**Subject:** Horsley Park Brickworks MOD 1 (SSD-9601-Mod-1)

## **Attachment 1: Environment and Energy and Science Group comments on Horsley Park Brickworks MOD 1 (SSD-9601-Mod-1) - Biodiversity**

### *Review of Biodiversity Development Assessment Report and Impacts*

Figure 4-1. Vegetation and threatened species surveys 30

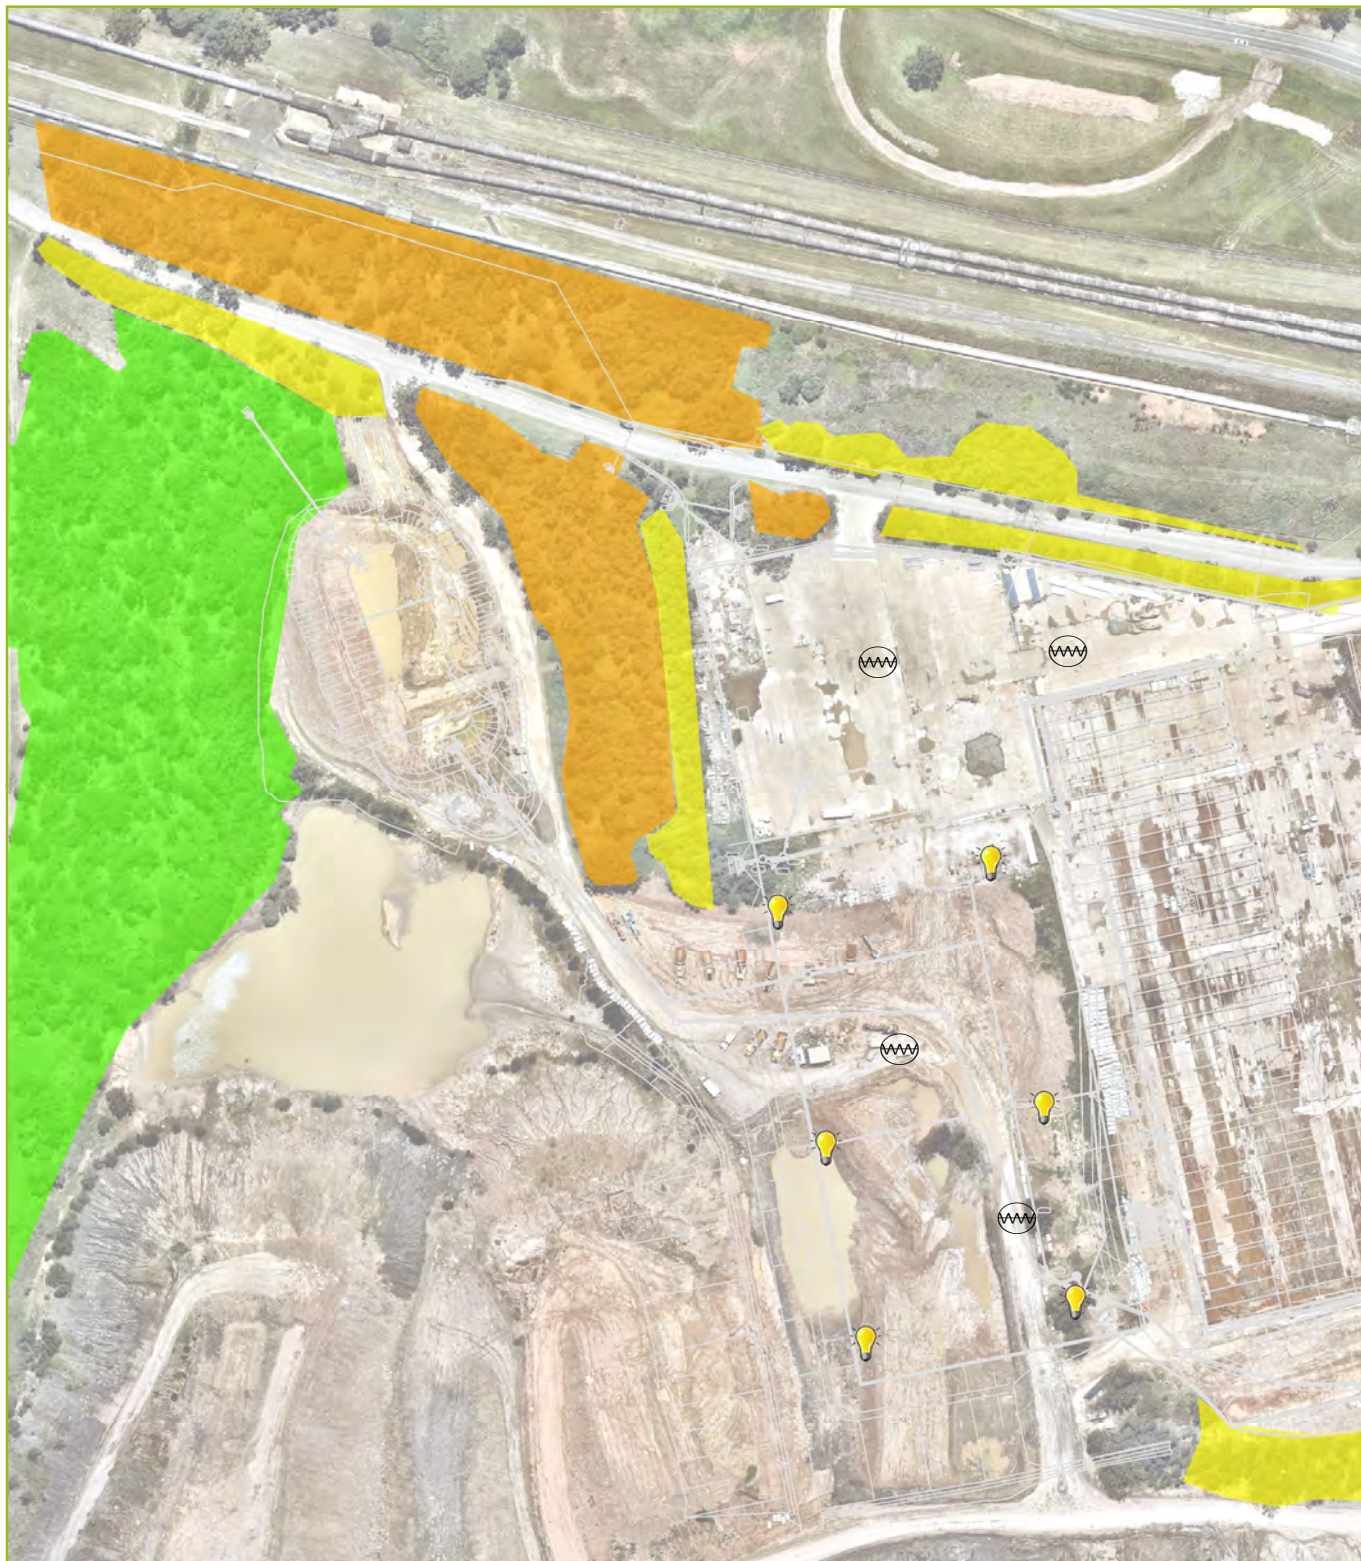
This is not the correct application of the BAM. In accordance with Steps 1-3 in section 5.2 of the BAM, candidate species do not require survey only if the habitat constraints or microhabitats are absent, or if the species is a vagrant, or if the habitat is degraded. Also, Figure 4-1 indicates the surveys undertaken by Cumberland Ecology were on a different part of the site.
